**Comments appertaining to  
ESSO's Site Specific Plans  
for SCP**

**Application by ESSO Petroleum Company Ltd  
for an Order Granting Development  
Consent for the Southampton to London  
Pipeline Project**

**Application Reference EN070005**

## Southwood Country Park Site Specific Plan

- NOTES**
1. Pipeline centreline alignment is intended only.
 2. Trees to be retained are shown based on the intended pipeline alignment.
 3. The illustration of existing trees on these plans is based on project survey data.

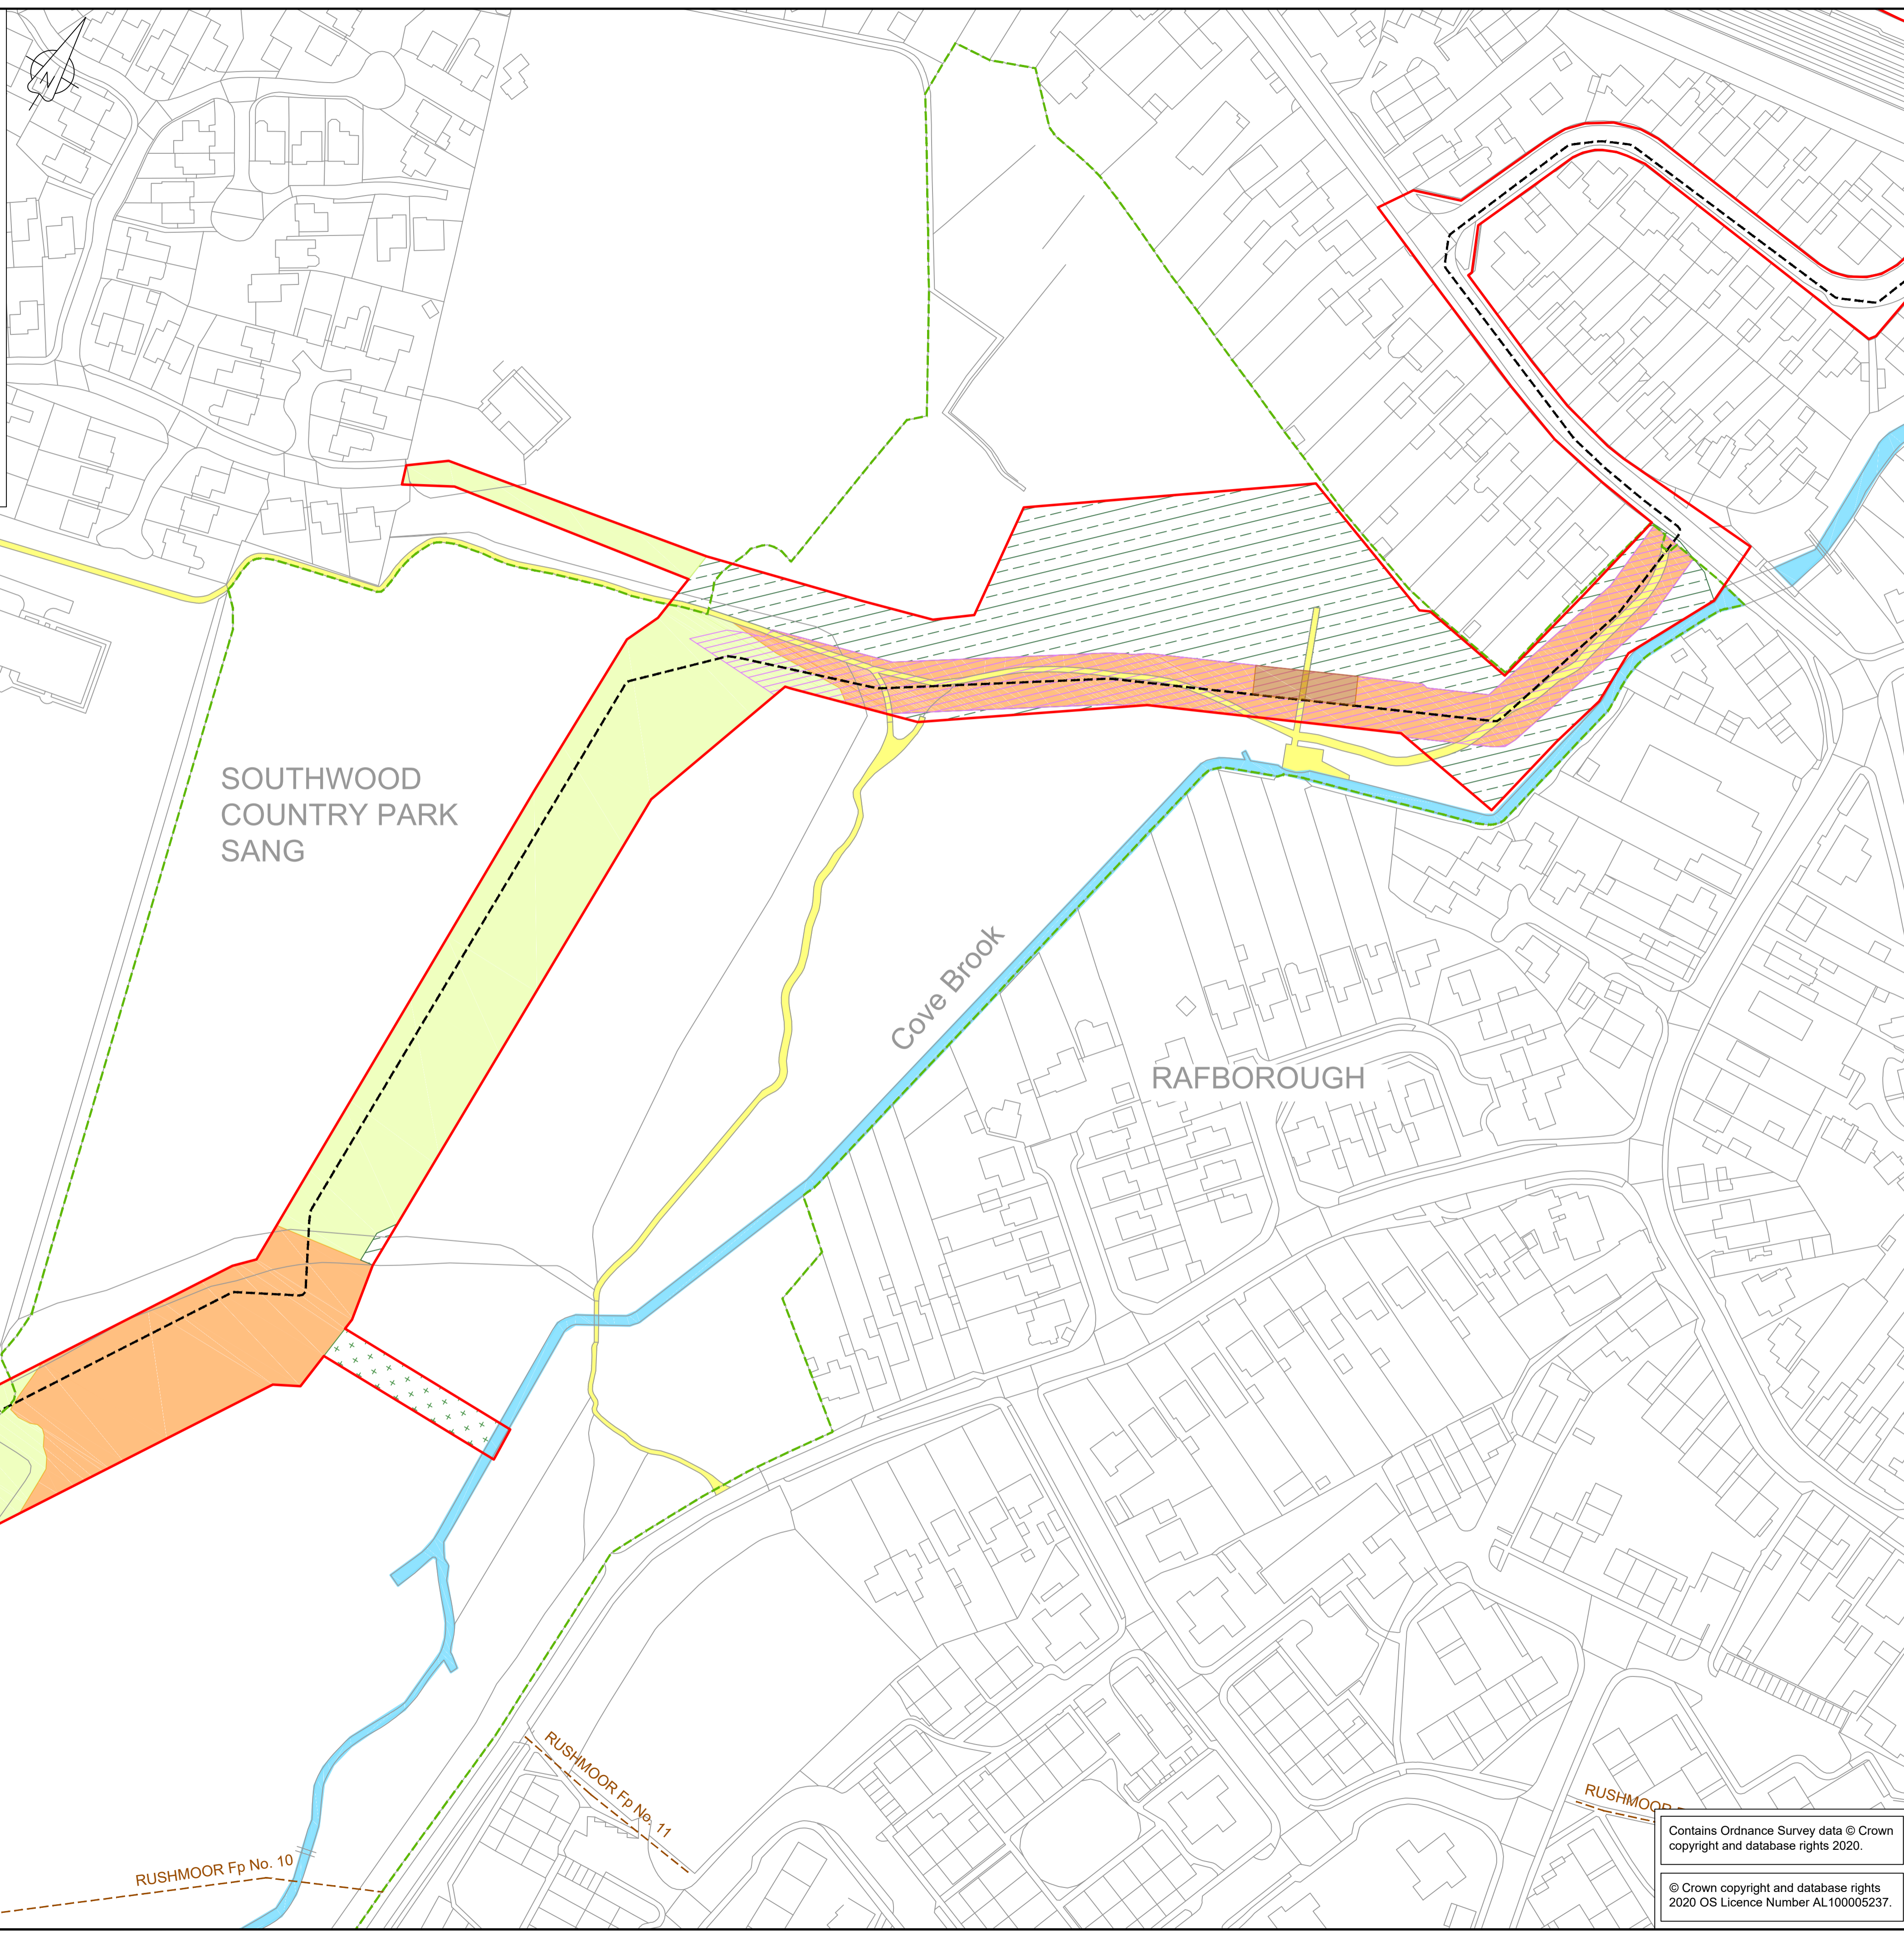
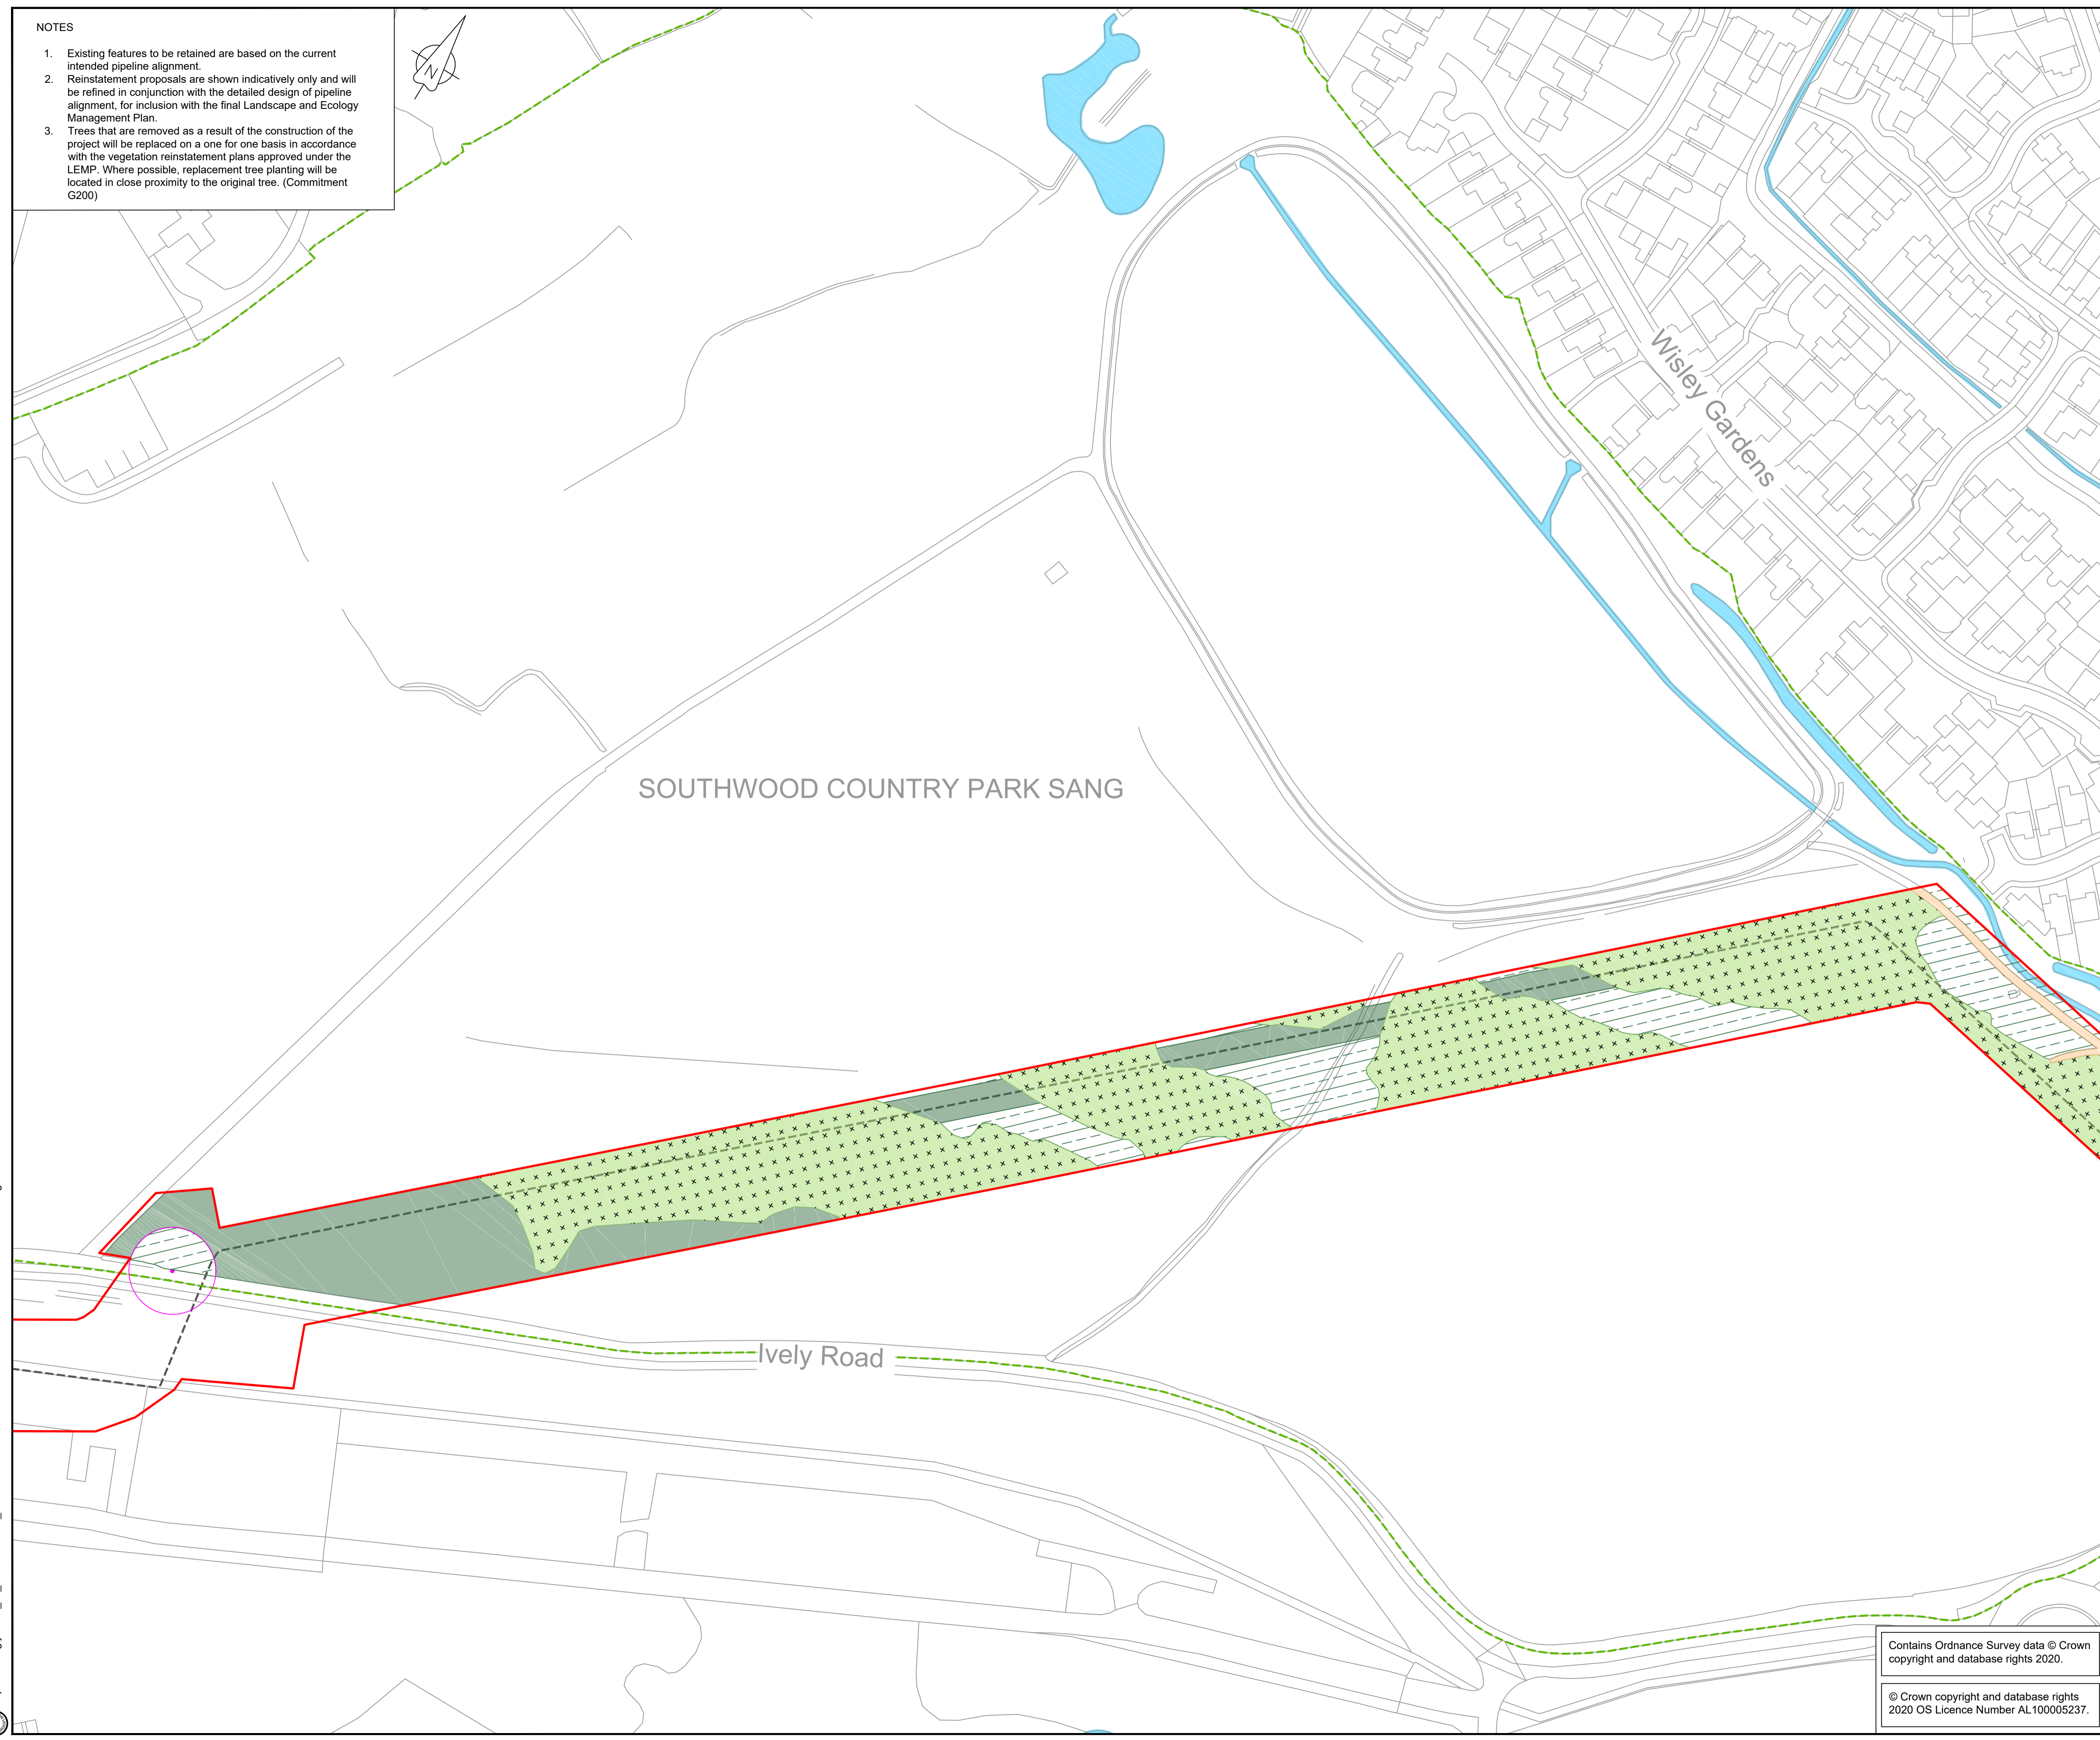
- 3.1.1 Within 3.1.4 there is mention of removal of 10m of a woodland belt. If this removal is essential for access then RBC would expect the tree loss to be mitigated on site, with mitigation negotiated after a biodiversity offsetting calculation or some other mechanism has been undertaken to assess the biodiversity loss.
- 3.1.2 Within discussions with the applicant they have not agreed to mitigate tree loss using offsetting but will only provide one to one compensation for mature tree felled. The council assume the mitigation will be in the form of whips and therefore tree loss on site is likely to lead to significant biodiversity loss. RBC is of the view that this is not adequate mitigation and would request that a mitigation package, including appropriate mitigation for tree loss within the Country Park be secured through a s106 agreement.

- 4.1.1 Again there appears to be significant tree loss to facilitate the auger bore this will require mitigation as above.

- 5.1.1 RBC recognises the sensitivity of the Dam and has therefore agreed this work can be done to the end of the bird nesting season. As this area is biodiverse the council would request that vegetation clearance is minimised in this area. Any clearance required would need to be mitigated. The council is discussing the creation of addition marsh habitat within Southwood Golf Course West SINC as part of the EIP, however it continues to be the council's view that any habitat mitigation should be secured as part of a s106 agreement and be linked to the planning process, rather than delivery as part of the EIP which is intended for enhancements.

- 6.1.1 This process will lead to the greatest damage to the Country Park with loss of hedgerow and grassland habitat. The council is particularly eager to ensure the acid grassland and marsh habitats are restored and mitigated within the project.
